FAO John Malcholc (planning application 3/2022/0082, The Old Garage Site, Newton Road, Dunsop Bridge )

I am writing in response to your recent correspondence with Dunsop Bridge Parish Council re. changes to the planning application submitted by the Duchy of Lancaster in respect of the Old Garage site, Dunsop Bridge (planning application 3/2022/0082). [REDACTED] representations when the application was first submitted.

Client	The Duchy of Lancaster		
Contract	OLD GARAGE SITE Dunsop Bridge		
Drawing title	PROPOSED SITE PLAN & BLOCK PLAN		
Scale	Job No.	Dwg No.	
1:250	KL2887	105	B

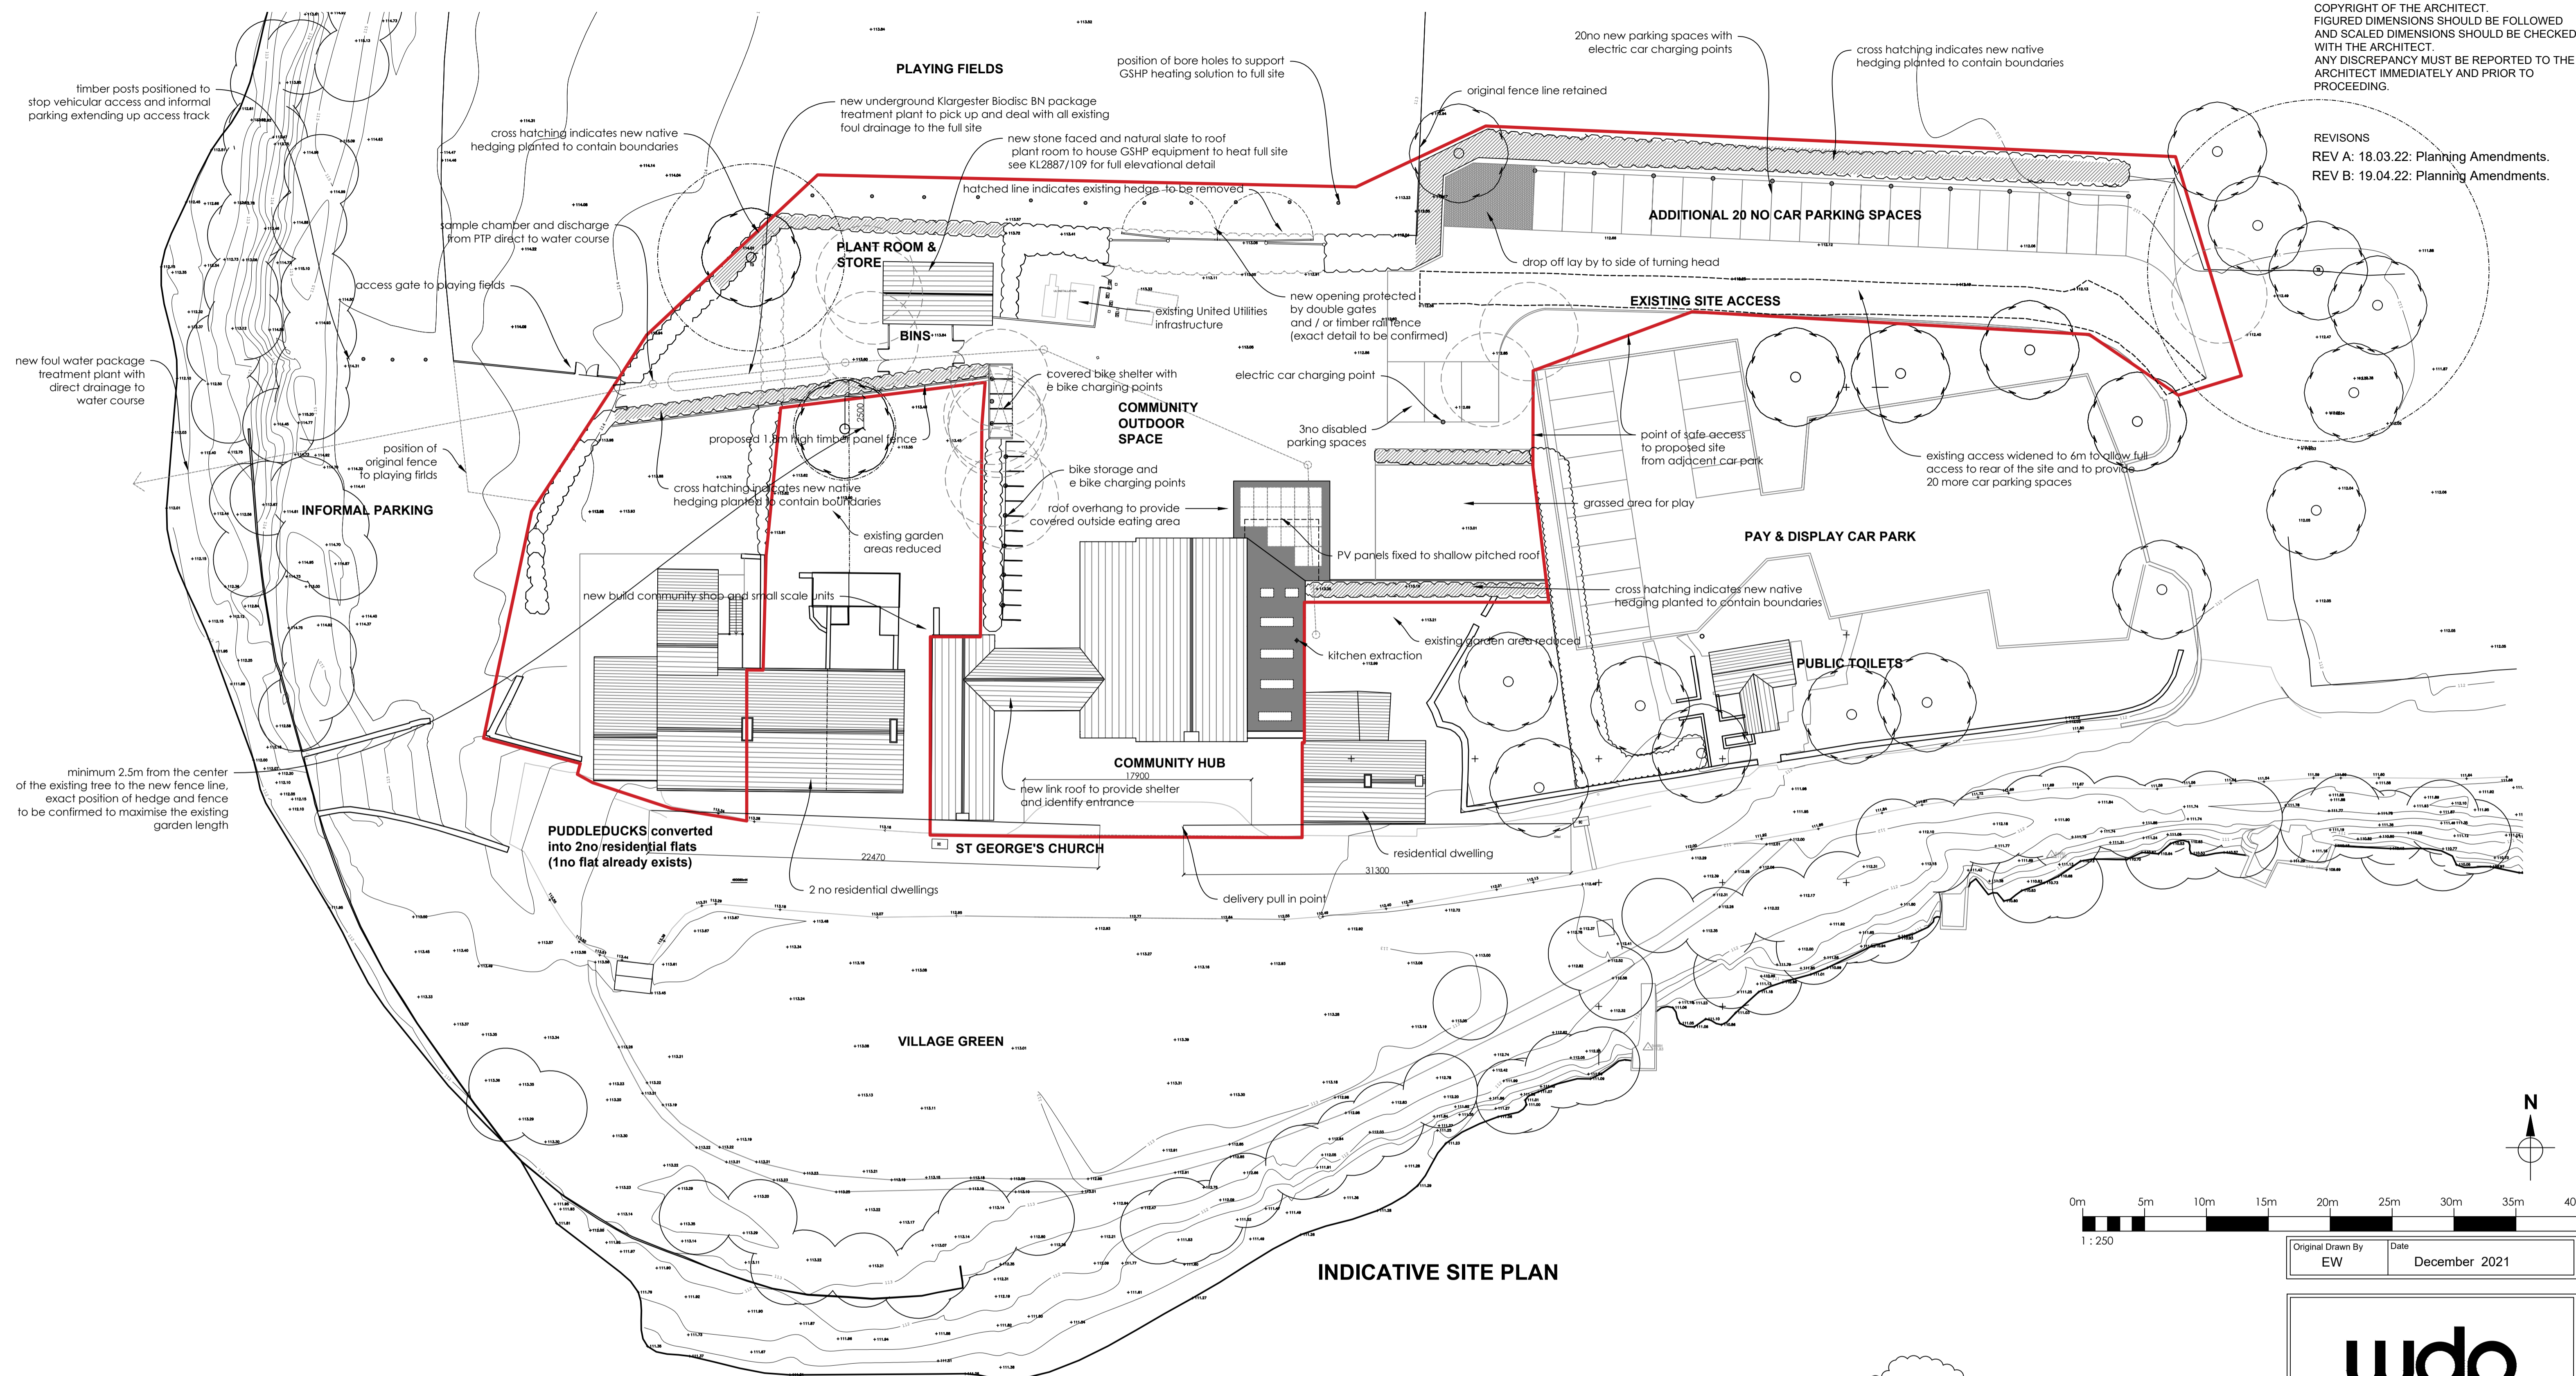
At a recent meeting of Dunsop Bridge Parish Council we discussed with [REDACTED] representative of the Duchy) the contentious issue of the rear of the cafe being open onto the field and the impact this would have on current use of the playing fields. [REDACTED] suggested the placing of 15' gates that could, on the occasions of lovely weather, be opened and suggested the possibility of this being a condition of planning permission. This would be an acceptable solution and enable much wider use of the field which is presently rented, from the Duchy, by the parish council, for the use of the community.

We do, however, still have concerns that the encouragement of visitors to access the village via the playing fields will result in a track being worn diagonally across the grass. The absence of a paved pathway will only exacerbate this problem and leave the field not fit for purpose.
